**RE: Nusenda Credit Union Admin Expansion  
Grading and Drainage Plan  
Engineer's Stamp Date 2/14/18  
Hydrology File: G16D154**

Based on the information provided in your submittal received 2/14/18, the Grading and Drainage Plan cannot be approved for Building Permit until the following comments are addressed:

LOWER LEVEL
GRADING and
DRAINAGE PLAN

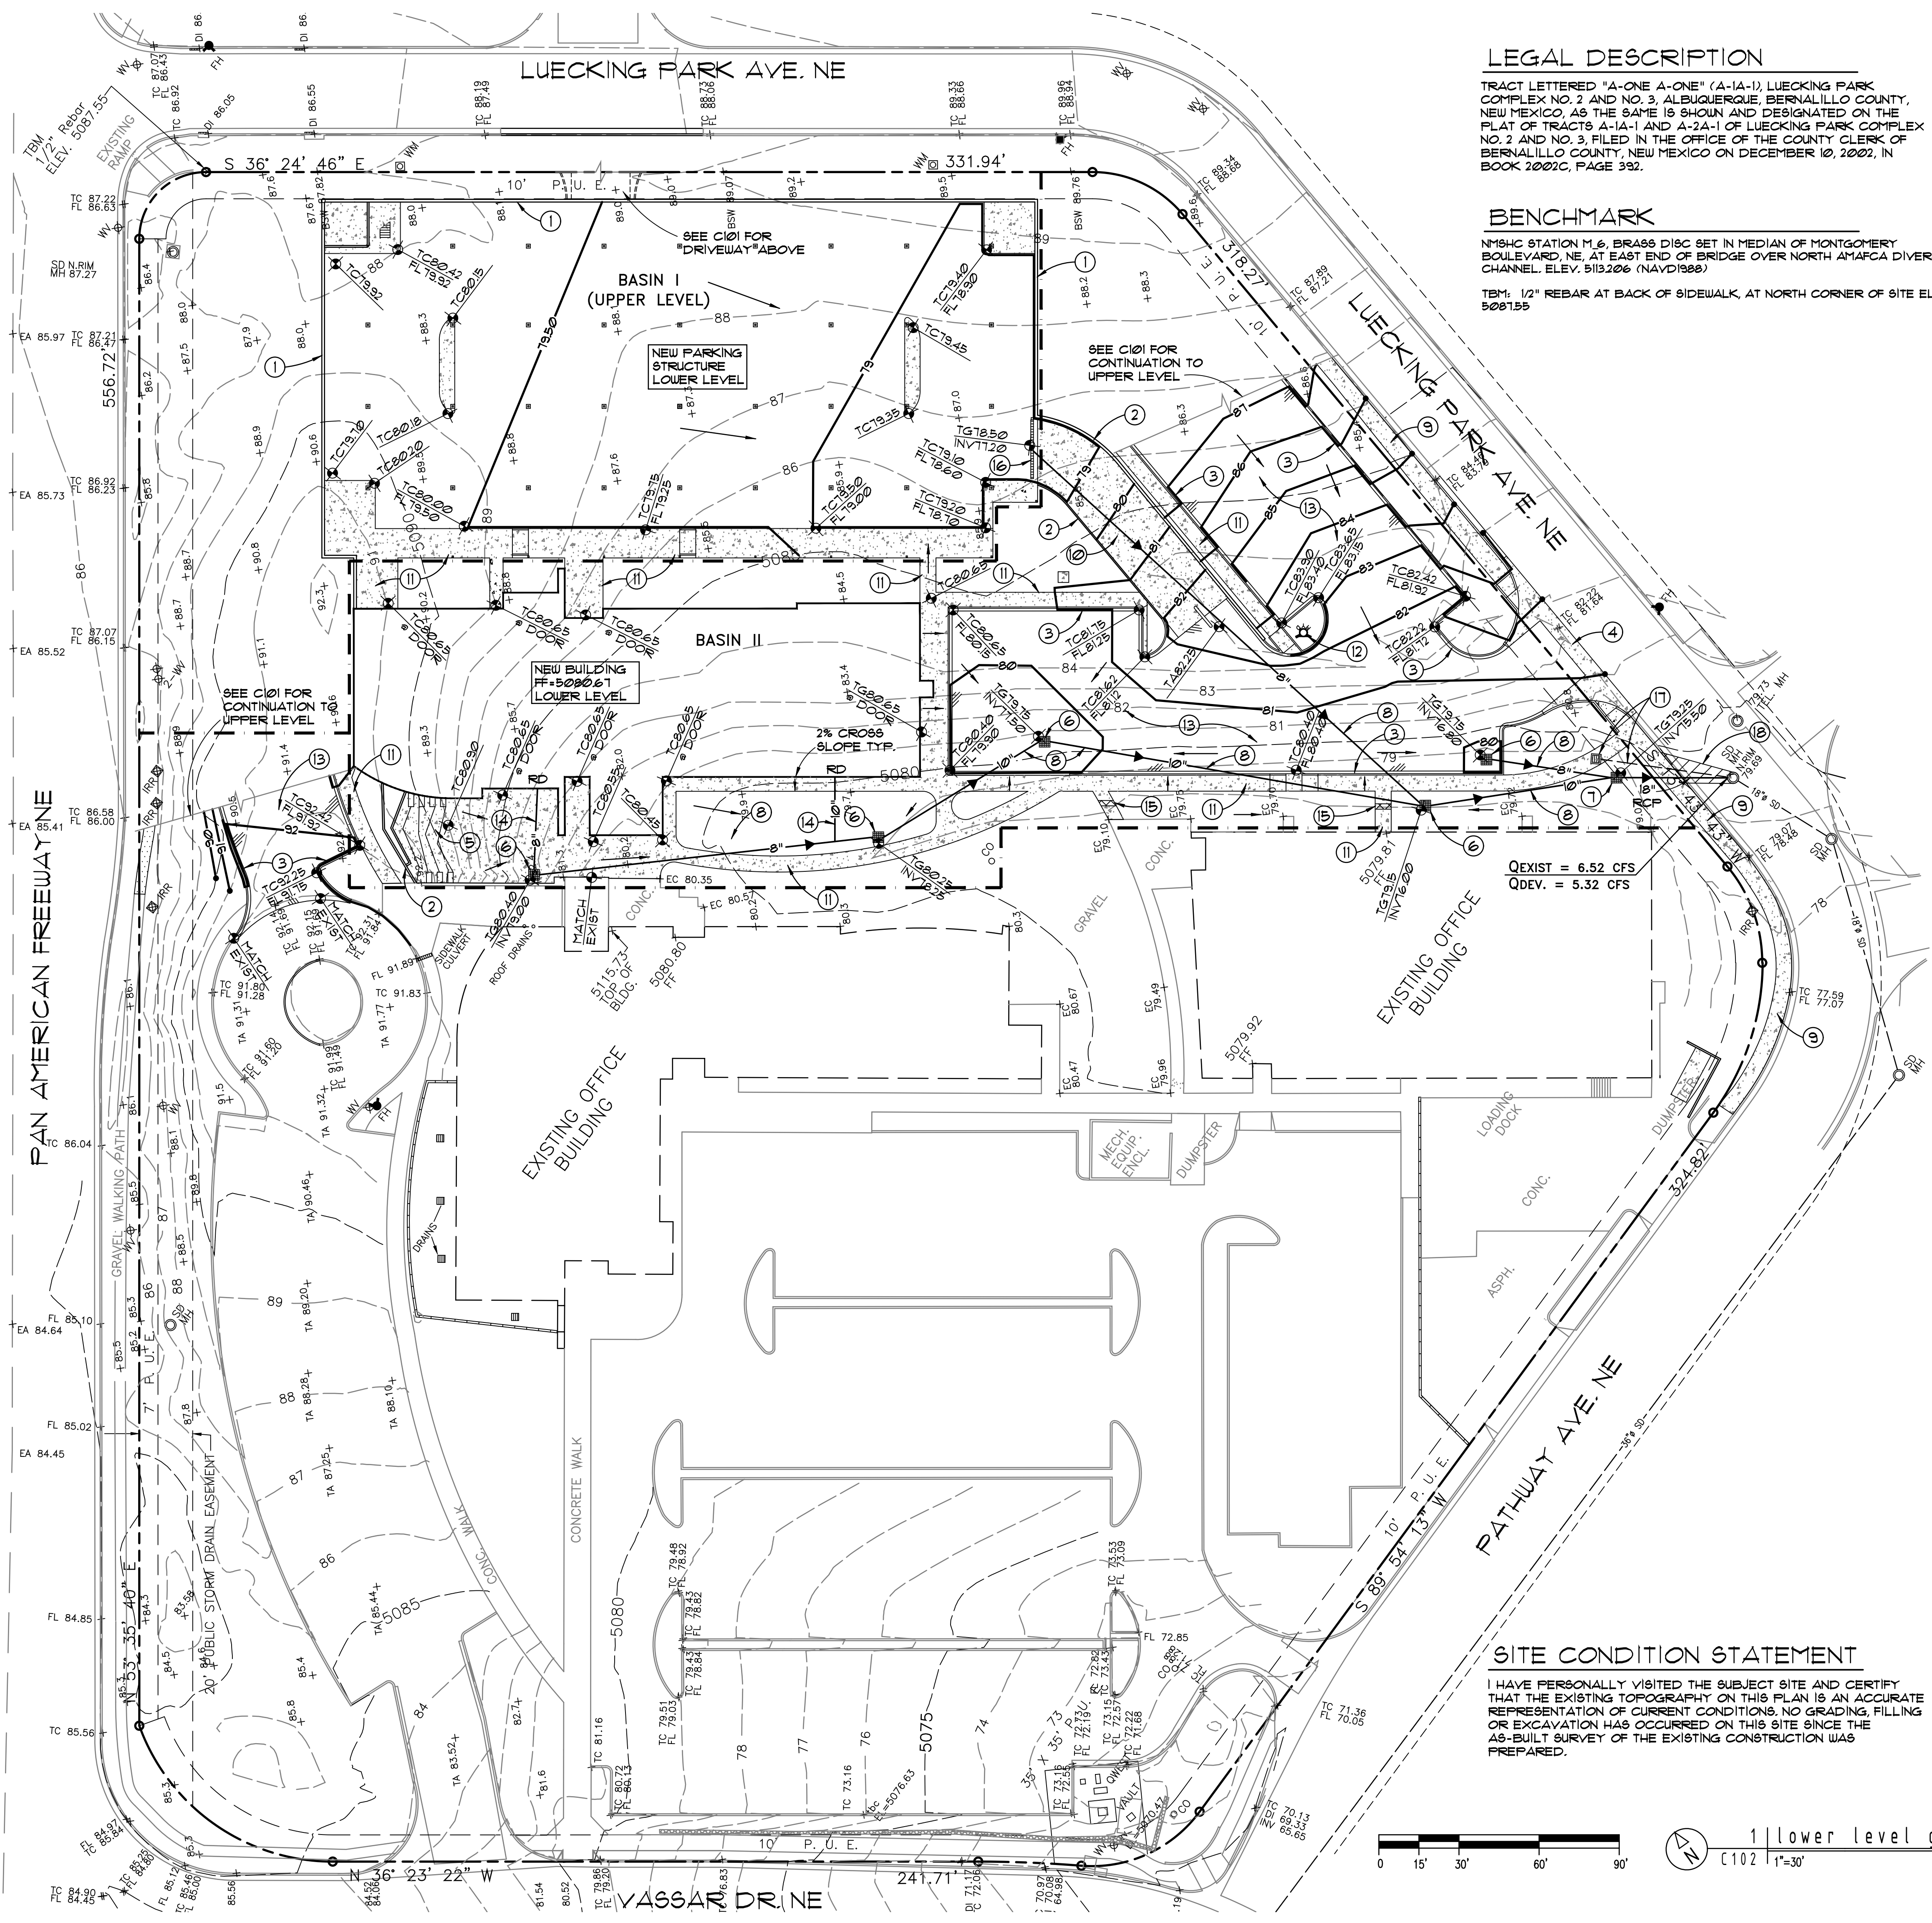
1. The first flush volume for the new impervious area needs to be quantified and retained on-site. If unable to pond onsite, payment of Fee-in-Lieu will be required at a rate of \$8/CF.

3. Are there any modifications or increases in runoff to Pan-American? If so, NMDOT approval is required.
4. Show the existing storm drain alignments along Pan-American and Luecking.

5. This project will require a public Work Order for the work along Luecking. Add a note to this grading plan that "No work is permitted in the Public Right-of Way without an approved Work Order" or similar.

6. Either a recorded SIA with financial guarantee or close-out of the public work order will be required prior to issuing Certificate of Occupancy.
7. Basin 2 appears to discharge to several areas: Basin 1, Pan-American, and Luecking. Please divide this basin and explain how each part of the site drains.

8. The new driveway and surrounding landscaping off of the cul-de-sac needs to be included in the site hydrology. Currently it does not appear to be a part of any of the basins.
9. The use of land treatment B is suspect. Compacted areas and sloped landscaping exceeding 10% are considered land treatment C. Please re-evaluate land treatments to be consistent with table A-4 of DPM Ch. 22.
10. This project requires an ESC Plan, submitted to the Stormwater Quality Engineer (Curtis Cherne PE, [ccherne@cabq.gov](mailto:ccherne@cabq.gov) or 924-3420).
